RE: Request for Advice - Atlassian Office and Hotel Development (SSD-10405) Central Precinct

Frank Howarth AO
Chair
Heritage Council of NSW
24 February 2021

DRAWING
SHED - SOUTHERN
ELEVATION
DOCUMENT NUMBER
DA-11C-GXX-02
ISSUE
6

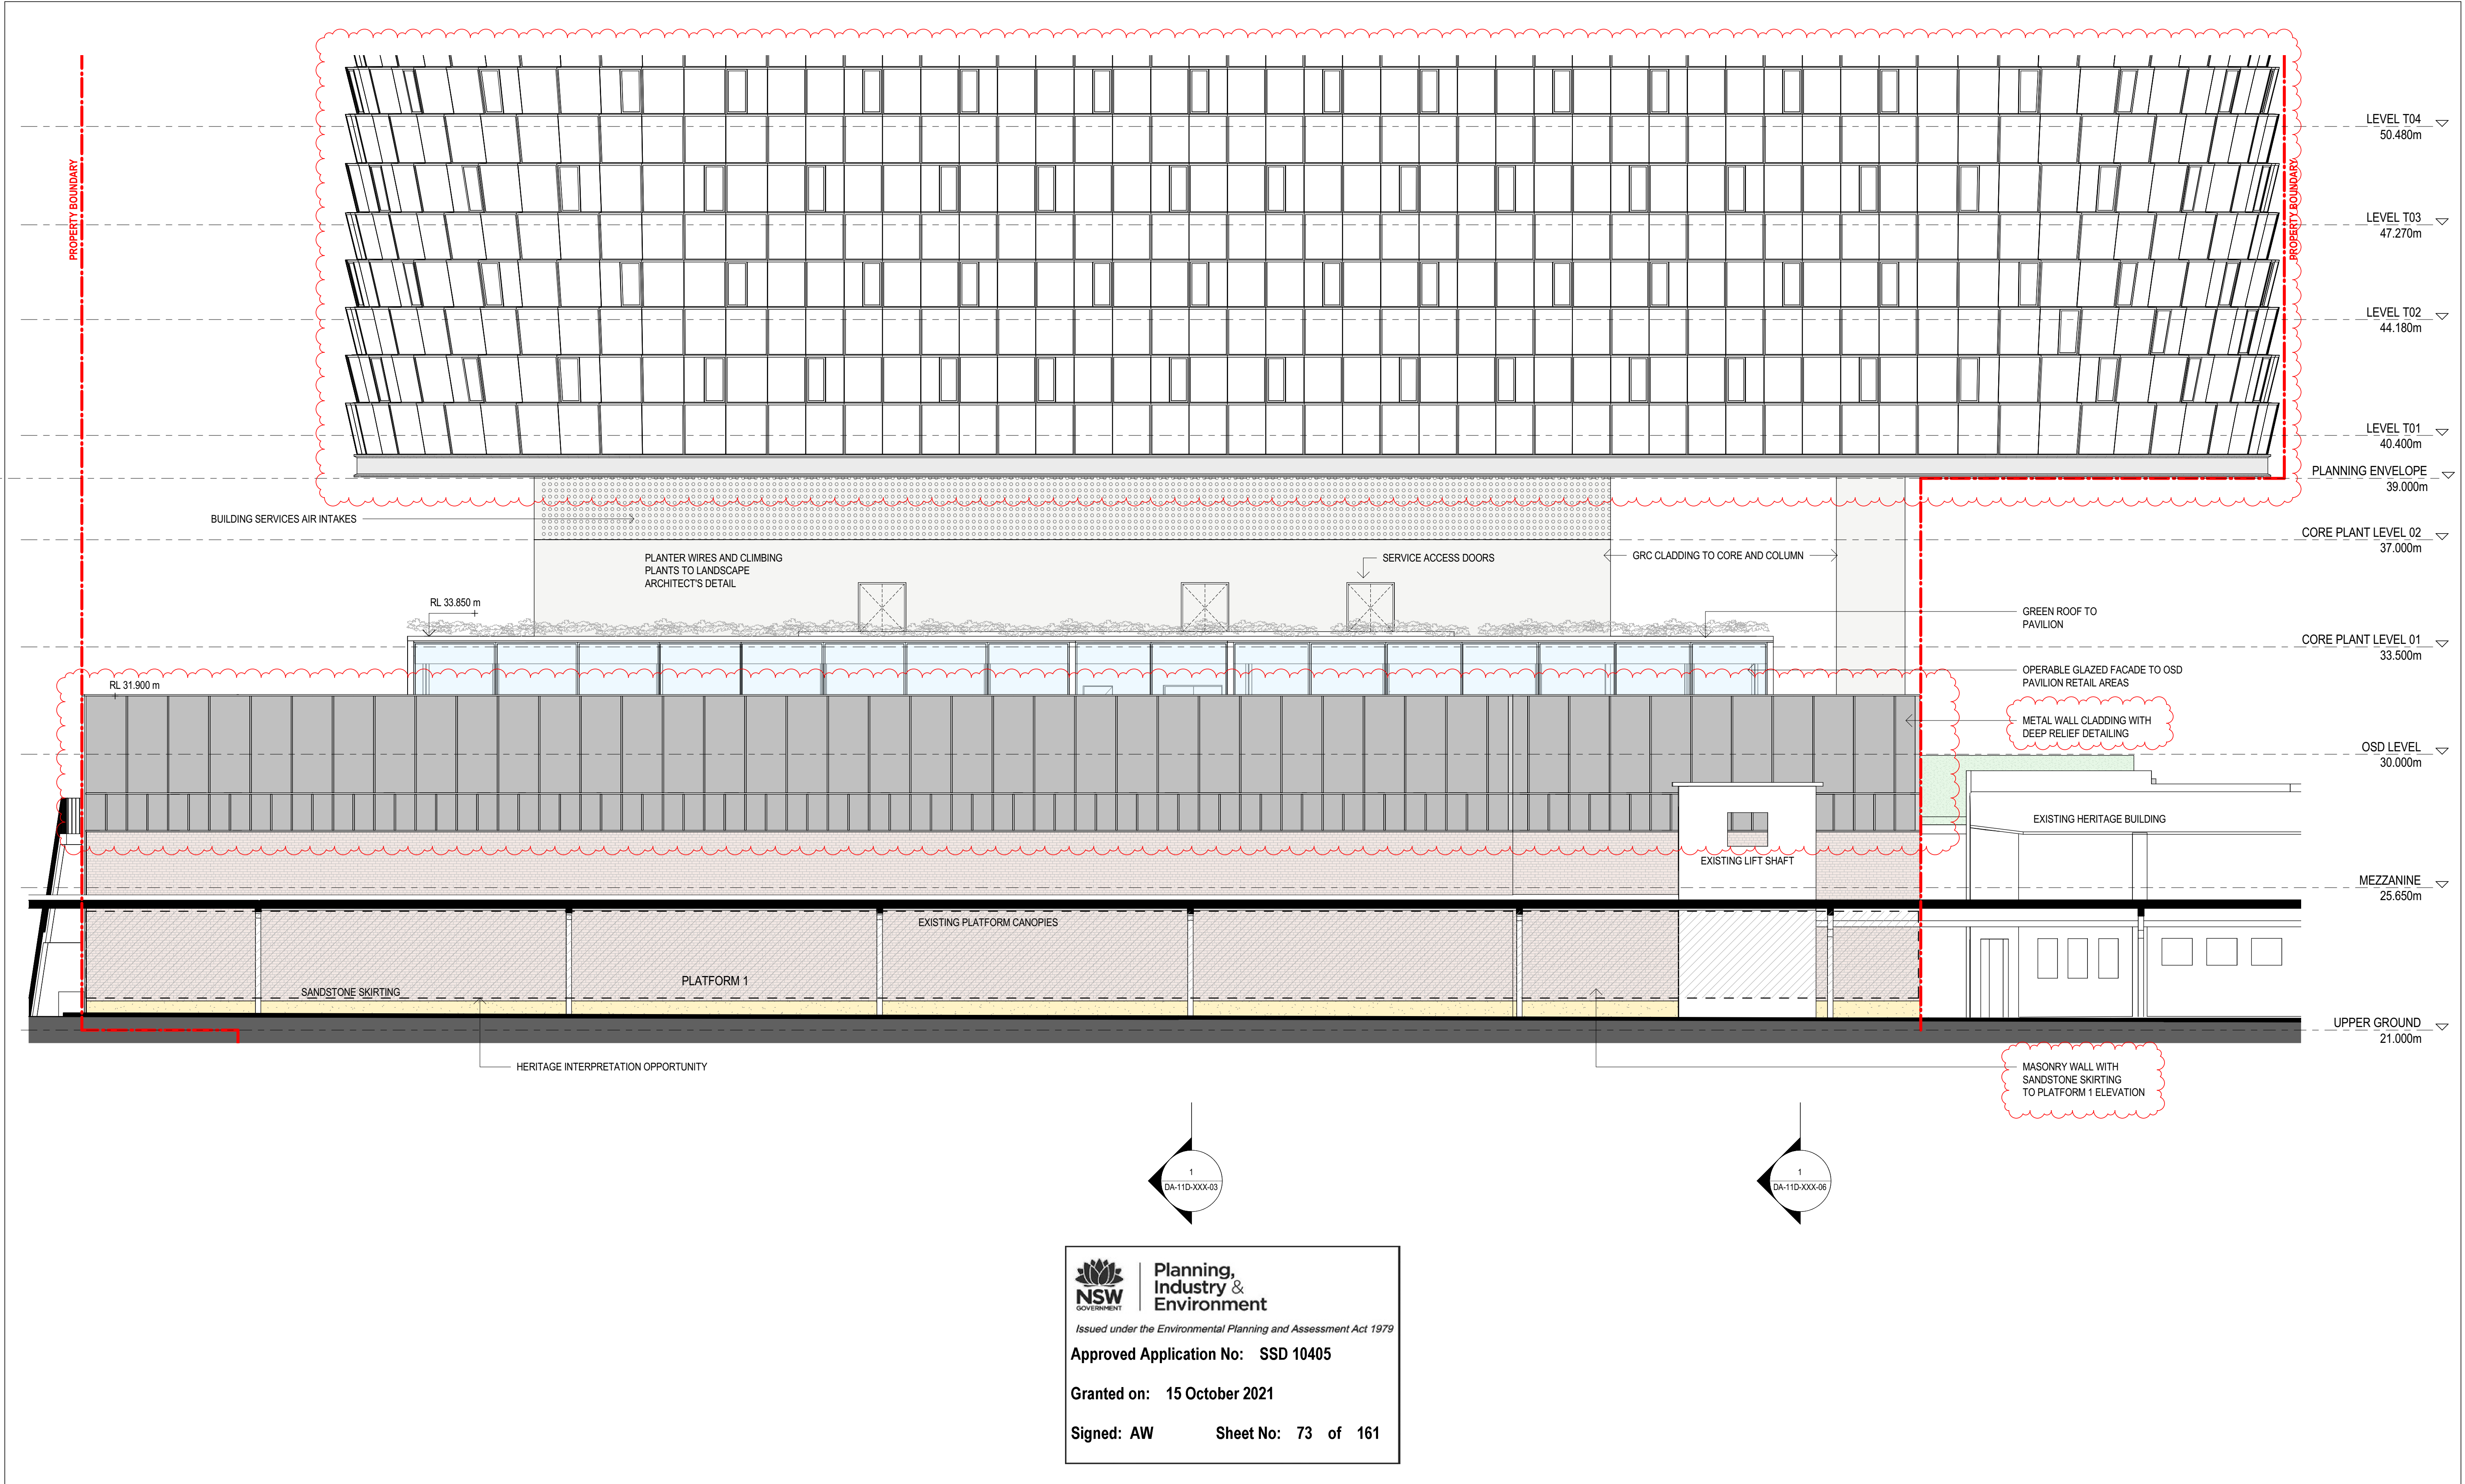
- We also suggest that the interface between the adapted Shed and Platform 1 (proposed 10m high masonry wall) sees further resolution. The proposed treatment of this interface removes the physical and historical connection between Platform 1 and the former

Inwards Parcels Shed. There is an opportunity, through architectural expression, to actively interpret the historic functioning of the Shed and the important and unique connection it had with Platform 1 and the broader Central Railway Station itself.

DRAWING
SHEP - EASTERN ELEVATION
DOCUMENT NUMBER
DA-11C-GXX-03
ISSUE
6

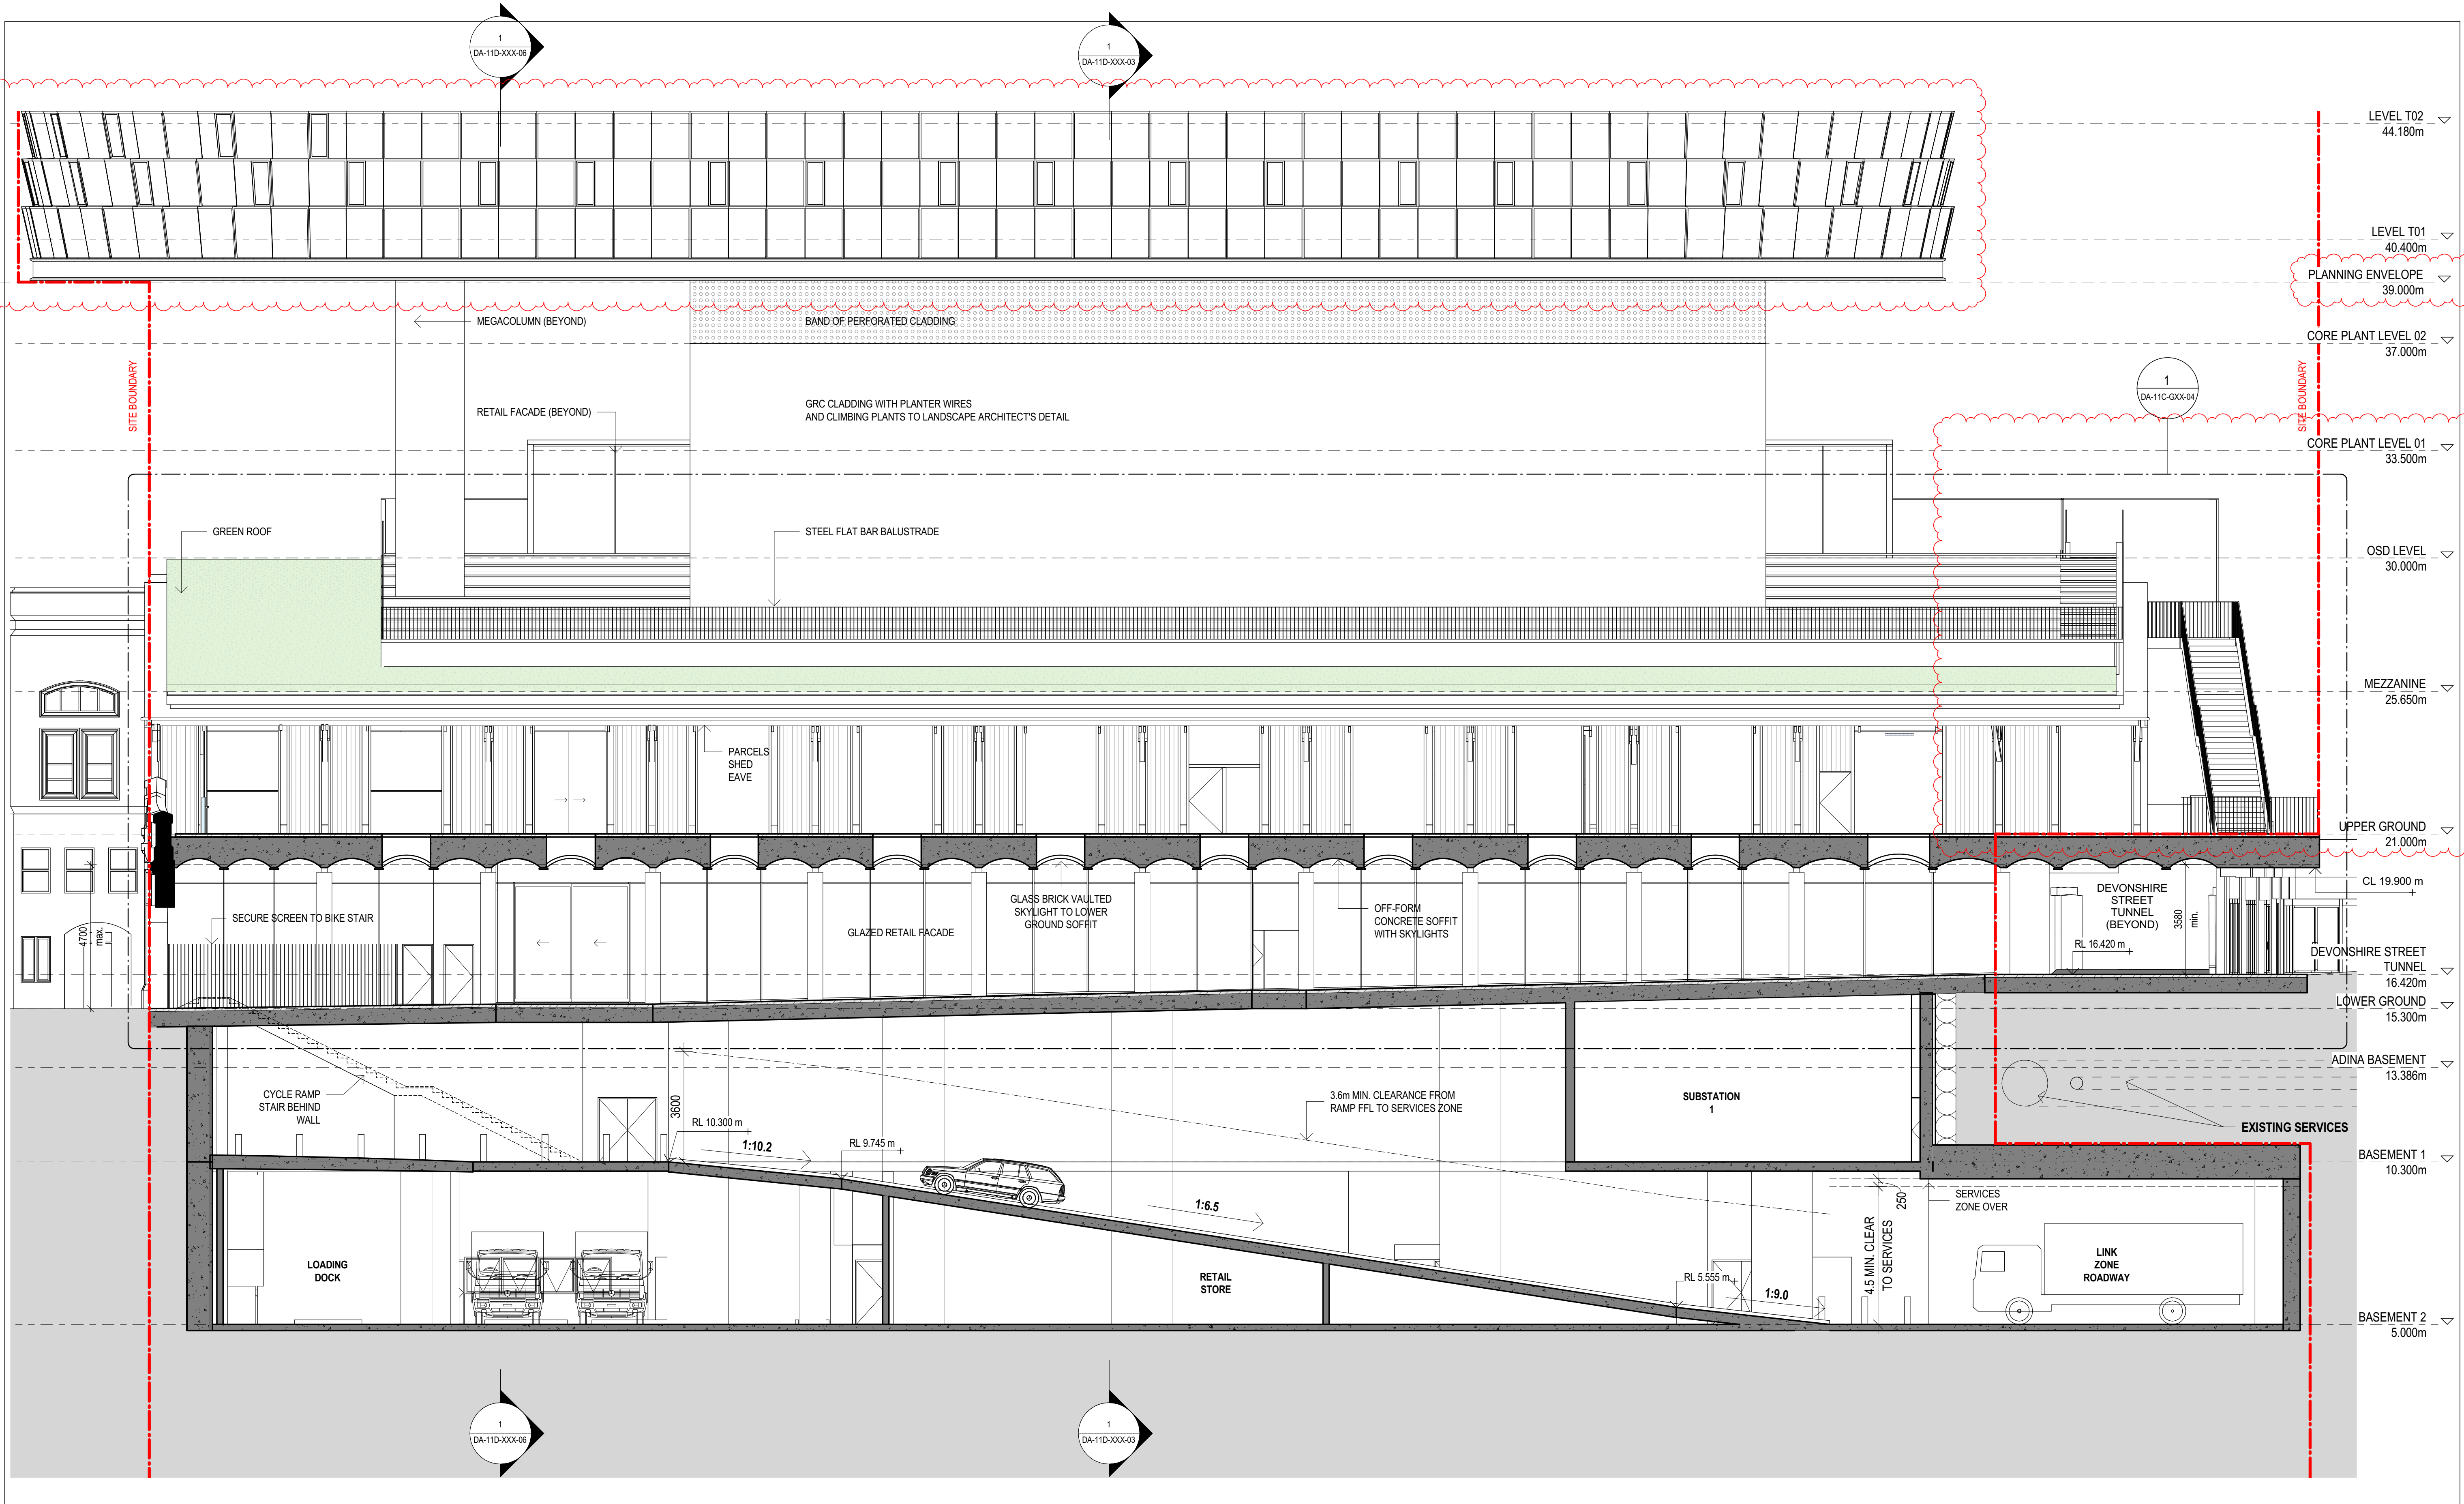
- It is acknowledged that further detail design development will be undertaken on the building and that as much original timber framing as possible will be reused in the building's adaptation. However, it is still unclear how other distinctive elements of the building, including the existing masonry base and chimneys, and sandstone plinths of the building will be meaningfully used as part of the adaptation and interpretation of the building. Further detail is required as per Heritage Council letter to the applicant, 16 October 2020.
